**WEST SUSSEX COUNTY COUNCIL
HIGHWAYS AND TRANSPORT SERVICES CONSULTATION**

DATE: 26th February 2008

SUBJECT: BE/1/08 - Outline for mixed use employment (Class B1 high quality business park comprising up to 19,500 sqm gross floorspace) and retail (Class A1 grocery store up to 4459 sqm net sales area) together with parking, new highway and associated servicing, infrastructure and landscaping.

Land at Oldlands Farm, Shripney Road, Bognor Regis, West Sussex

5.4 Layout

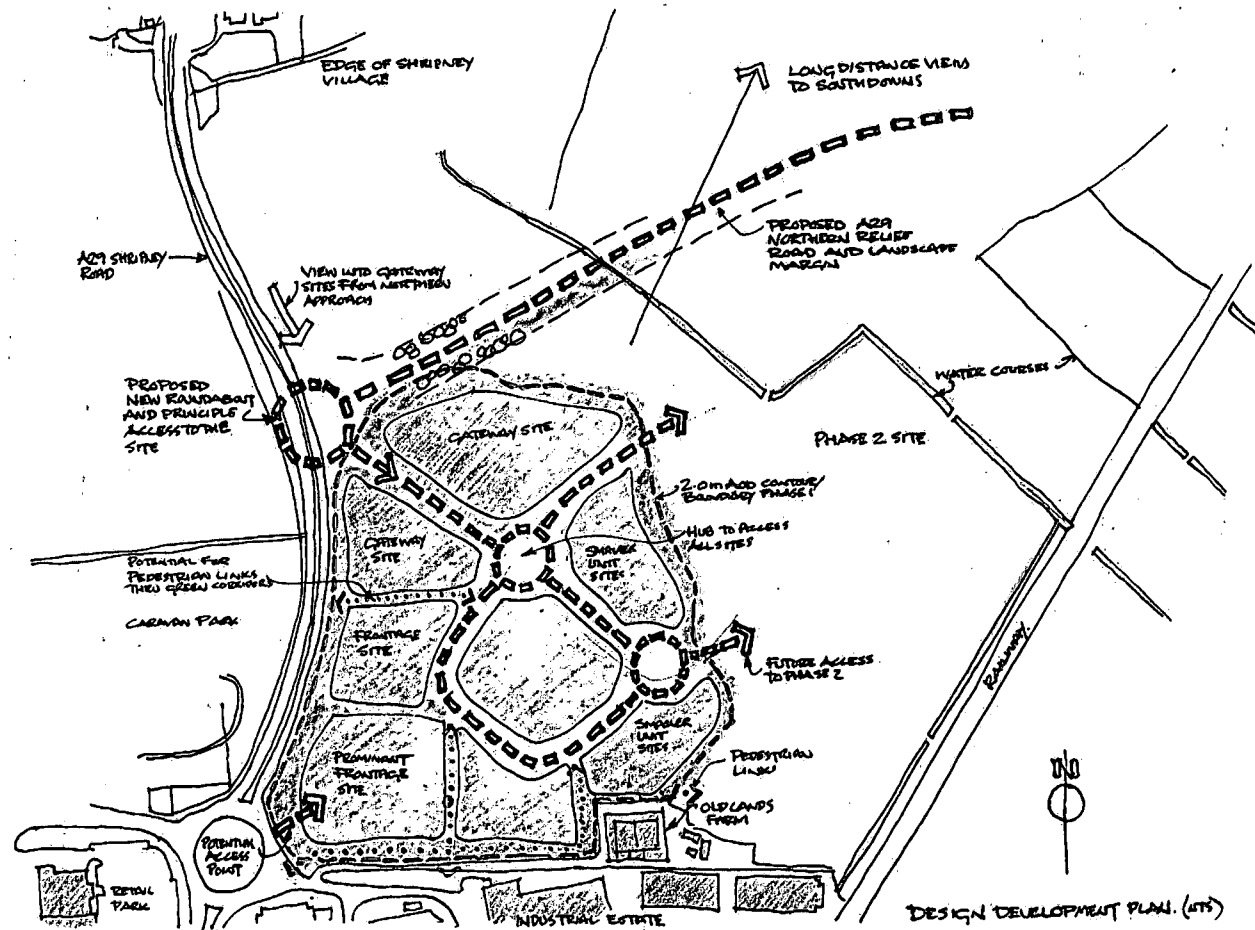
However, there is an area of concern with regard to the proposed internal walking network as the sit plans do not provide for a footway adjacent to the bus link. It would be of benefit to provide a footway alongside the bus-only link to provide for foot trips to the northern part of the business park without having to cross the store car park and to discourage walking in the bus road carriageway.

**A29 / ROWAN WAY – POSSIBLE
SIGNALISED ROUNDABOUT**

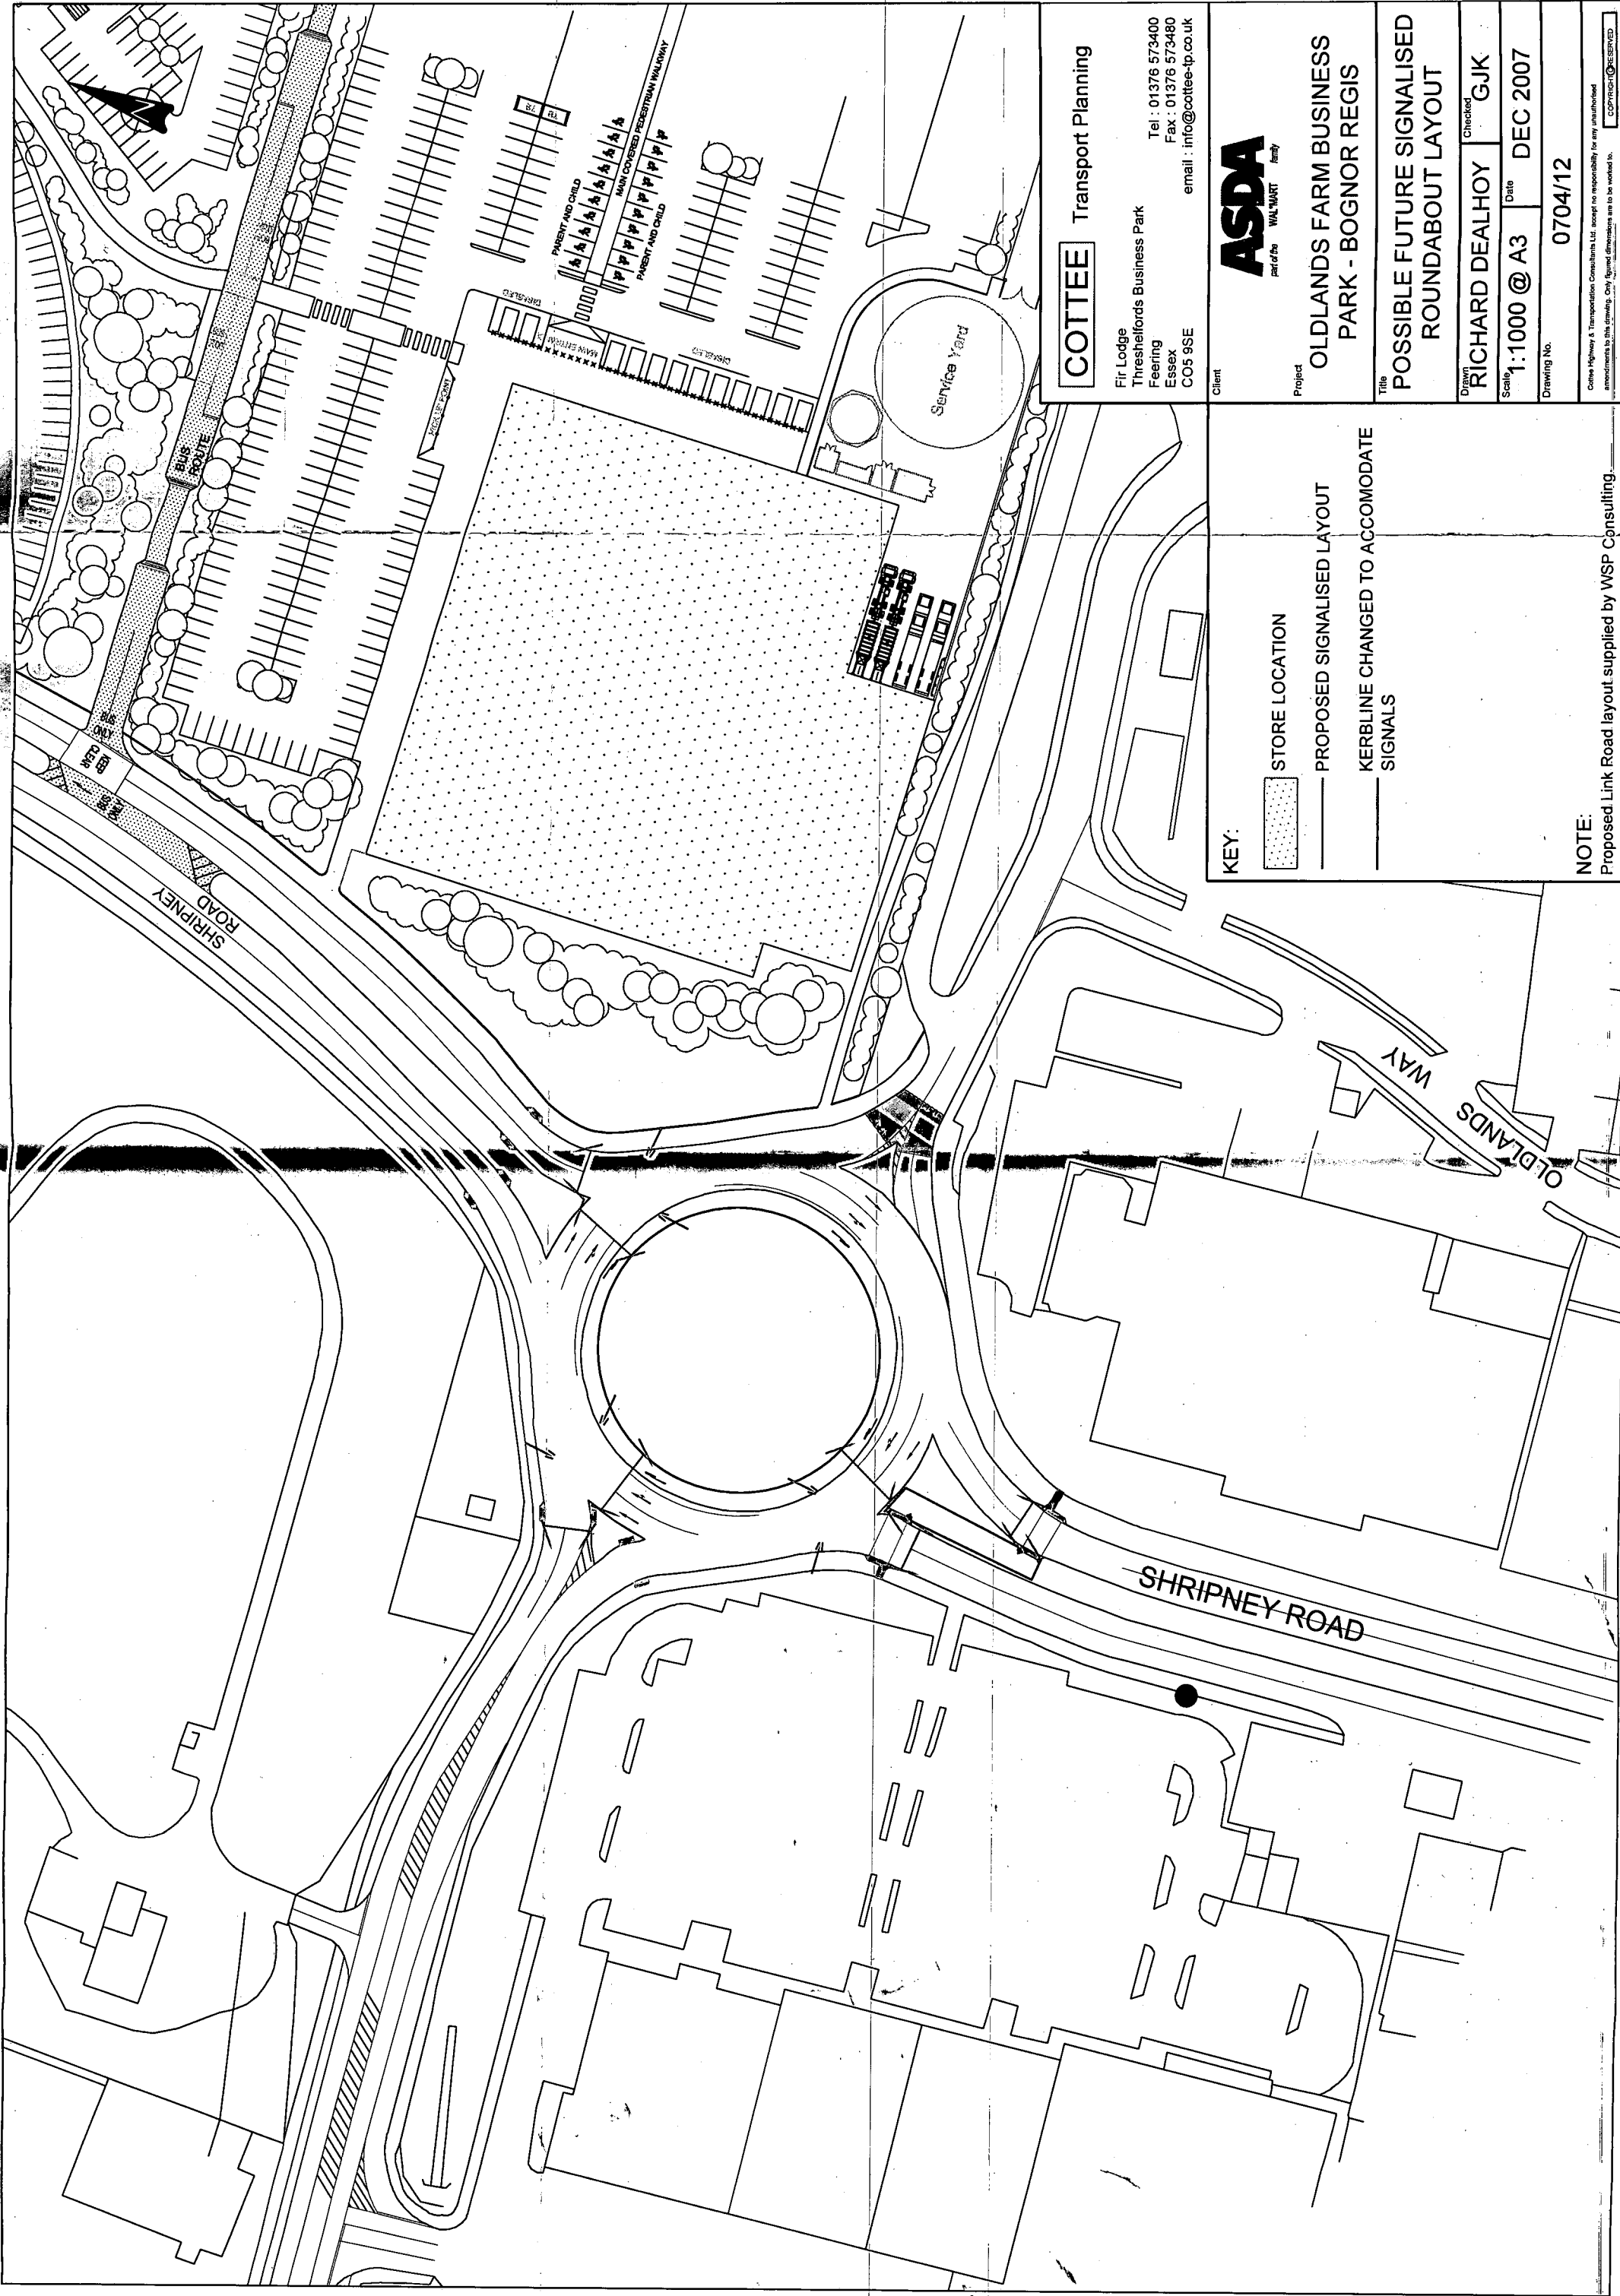
Rowan Way Junction ARCADY has been checked and geometric inputs are OK. The junction goes over capacity in 2025 PM peak, requiring the traffic signals scheme. However, this is also on the basis of disputed traffic figures used, and little weight can be attached to this until the above discrepancies are accounted for and the 65% figure for diverted Tesco traffic confirmed.

Rowan Way Junction TRANSYT will also need to be re-assessed on the basis of the disputed figures.
